**RE: 280 Warren Avenue – Building Addition
Level II Site Plan Review
Application ID Number: 2011-300**

TO: Jean Fraser, Planner
FROM: Ashley Auger, E.I.T. & David Senus, P.E.
DATE: July 21, 2011
RE: McFarland Spring Corporation – 280 Warren Avenue

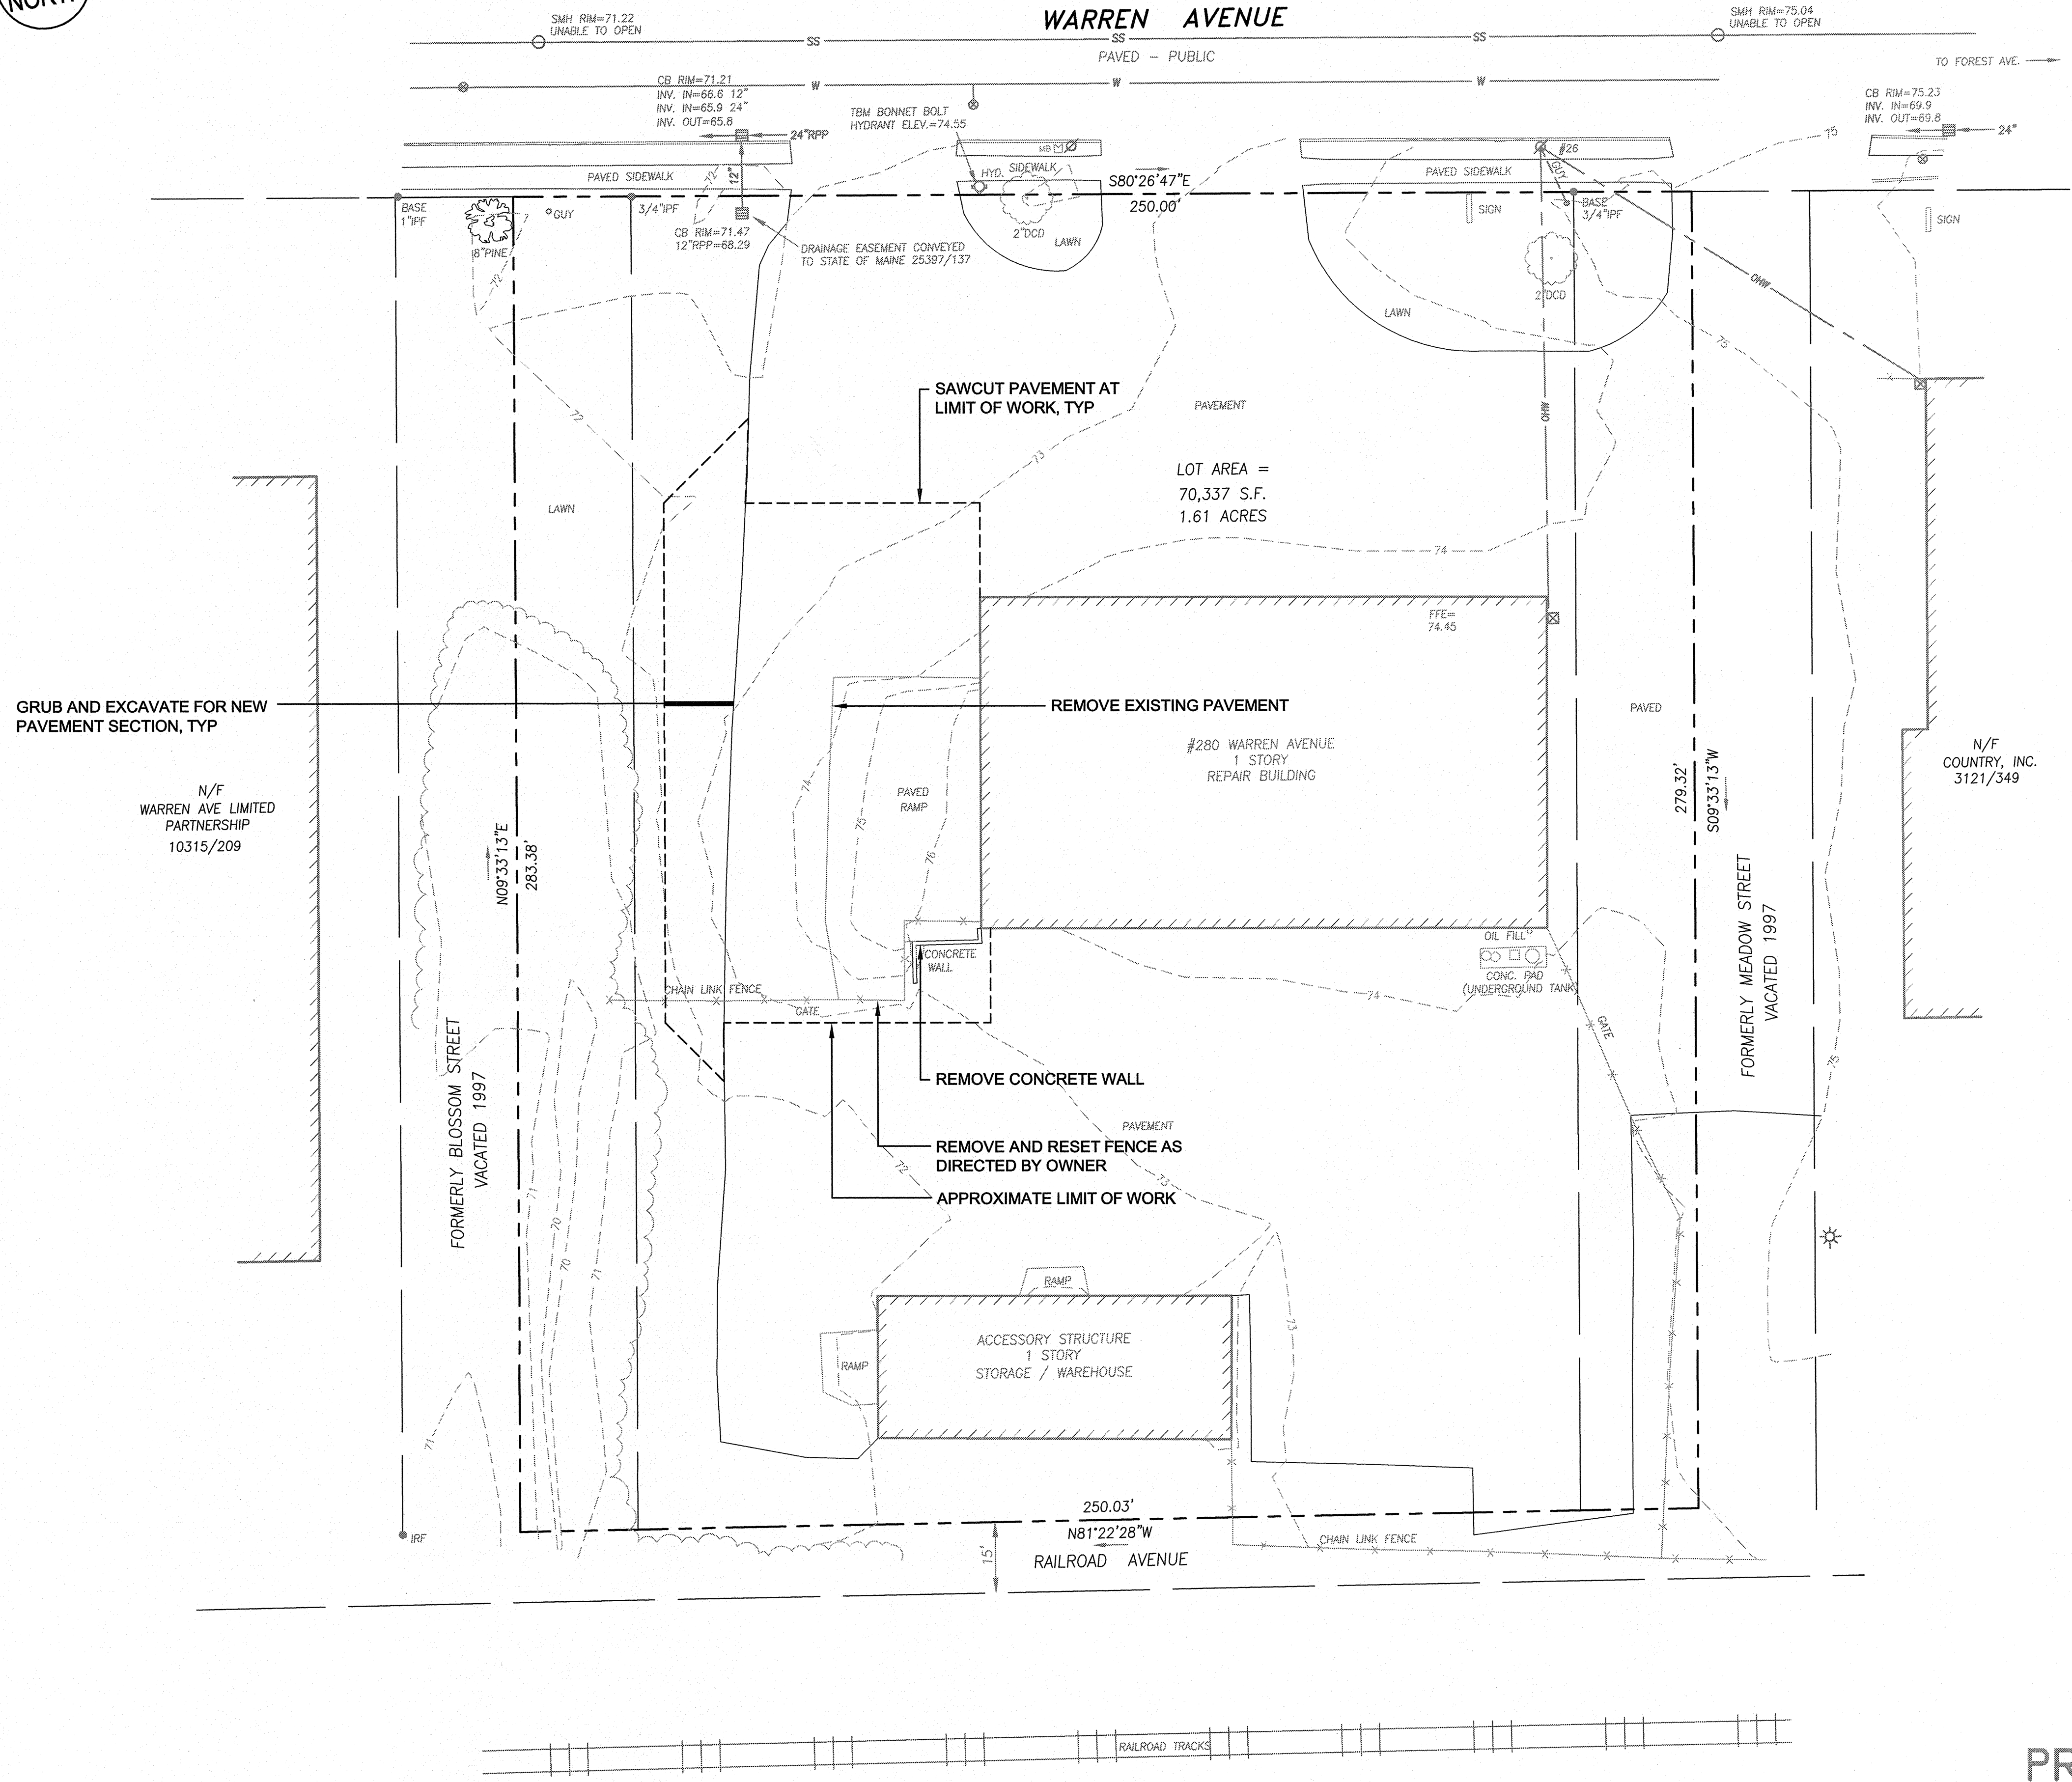
- The site currently has three access/egress points* on Warren Avenue and we would suggest that one of the driveways be closed; based on our site investigation, we would suggest that the westerly driveway be closed. If you do not want to close any of the

driveways, please submit information that documents the need for all curb cuts, including Auto-Turn graphics and other supporting documentation.

- The site plan survey is incomplete since the property corners have not been set. All property corners shall be set before a building permit is issued.
- *The eastern-most access is located on the former Meadow Street. The survey does not show that the applicant has an easement to use that access, which is mostly on the part of the former street owned by the abutter. If this is the case (ie no easement for access here) then the layout should be designed (see Parking and Traffic comments) to operate without that access.

(G) GRAVEL CONSTRUCTION ENTRANCE/EXIT
N.T.S.

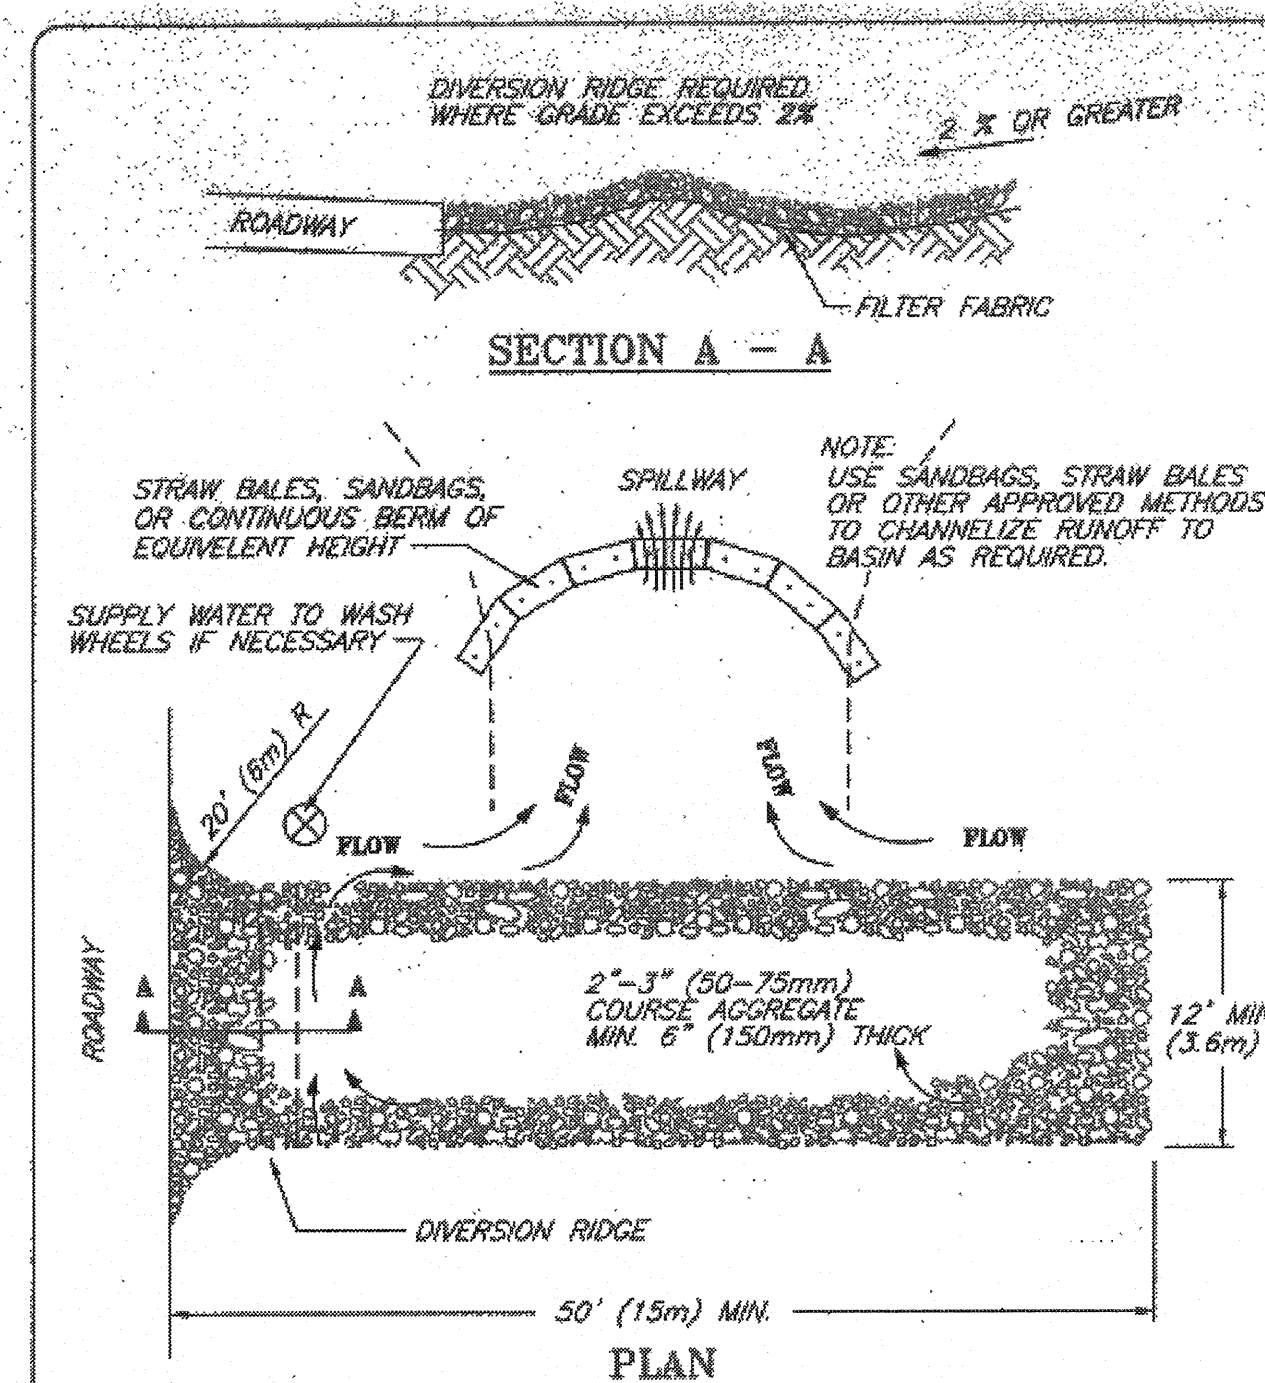
- Please provide a detail for the proposed stabilized construction exit per B-4 of the MaineDEP Erosion and Sediment Control Best Management Practices Manual.
